Figure 3 - Hydrological-hydraulic operation of catchment

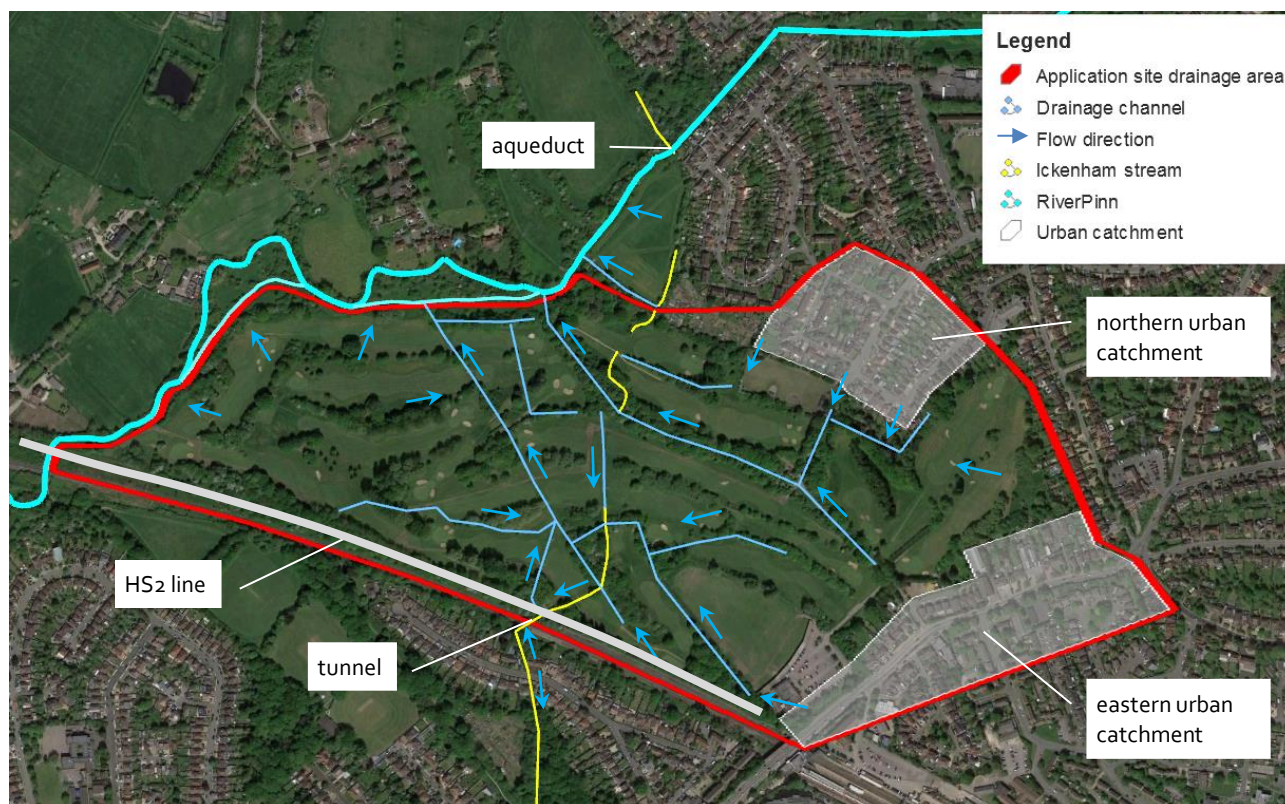
The catchment to the south of the Chiltern Mainline is acknowledged but not included in calculations. No assessment in reality has been made of the Thames Water Network in this area which it stated has been used to inform this catchment area. It is not therefore clear that the appropriate catchment areas have been used to estimate run off though the golf course.	<p>As is described in the Drainage Report Section 3.2.3, Sub-catchment SC4 comprises the areas located to the south of the Chiltern Mainline and to the north of Greenway Road (which partially drains to the north of the application site). However, due to the proposed HS2 works at this area, runoff from SC4 will be drained to the Ickenham Stream stretch located at the South of the HS2 line.</p> <p>Available information of existing Thames Water sewer system shows that run off in this area is conveyed by the sewer system and connected with the Greenway Sewer Pipe that drains to the South from the Chiltern line.</p> <p>A more detailed description of this drainage system will be provided in a Drainage Design Report proposed to be secured via a pre-commencement condition.</p>

Figure 18 - West and east catchments and flow control outfalls

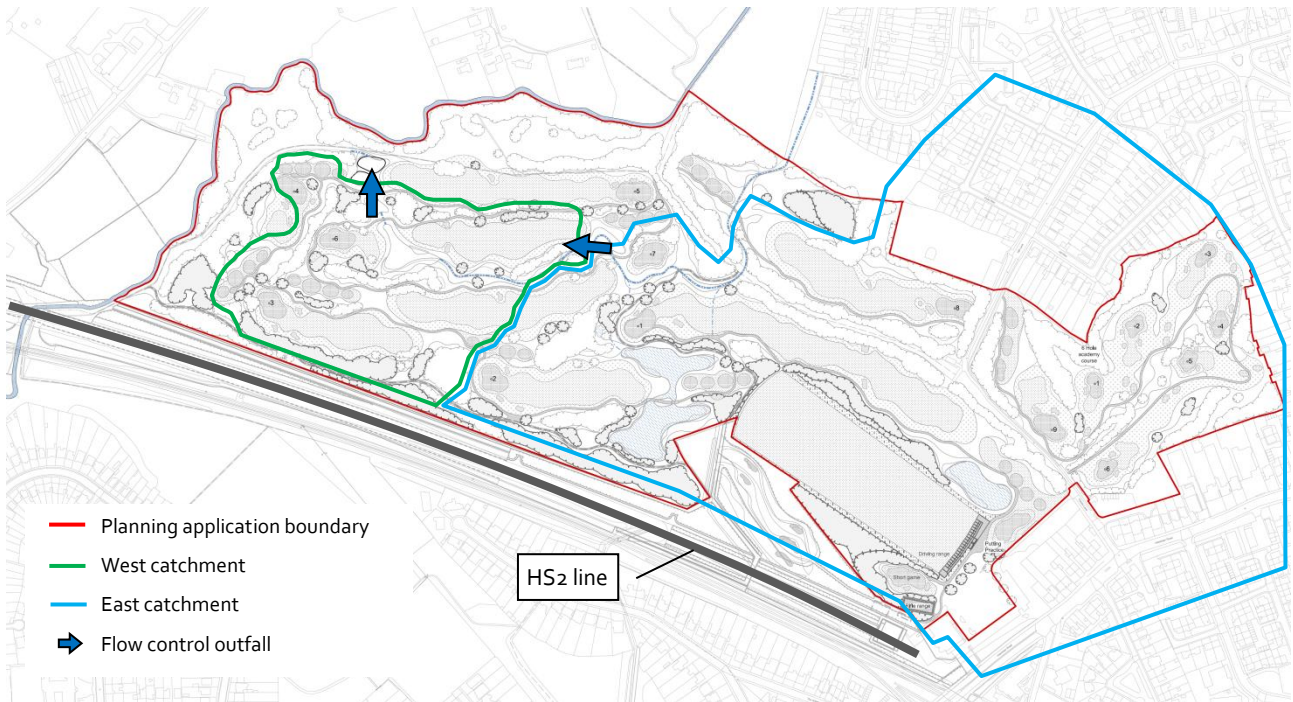
Officer Query	Applicant Response
Drainage outfalls are not clearly identified within the submitted report, nor are the actual areas that drain to these points made clear.	<p>Information received regarding discharges from Thames Water sewer system for the eastern and northern urban areas are shown in Drainage Report Figure 3.</p> <p>All run-off from catchments which discharge into the existing and proposed ditches and swales have already been considered in the hydraulic calculations. These catchment areas were already considered as part of sub-catchments SC2 and SC1 respectively (areas shown in Drainage Report Figure 3).</p> <p>Information provided by Thames Water includes hydrographs for different return periods and rainfall durations and the specific location of the discharge point. The images below illustrate the sub-catchments defined by Thames Water for the analyzed urban areas:</p> <p>Northern: </p> <p>Eastern: </p> <p>It is proposed this additional information will be provided by way of an appropriately worded planning condition.</p>
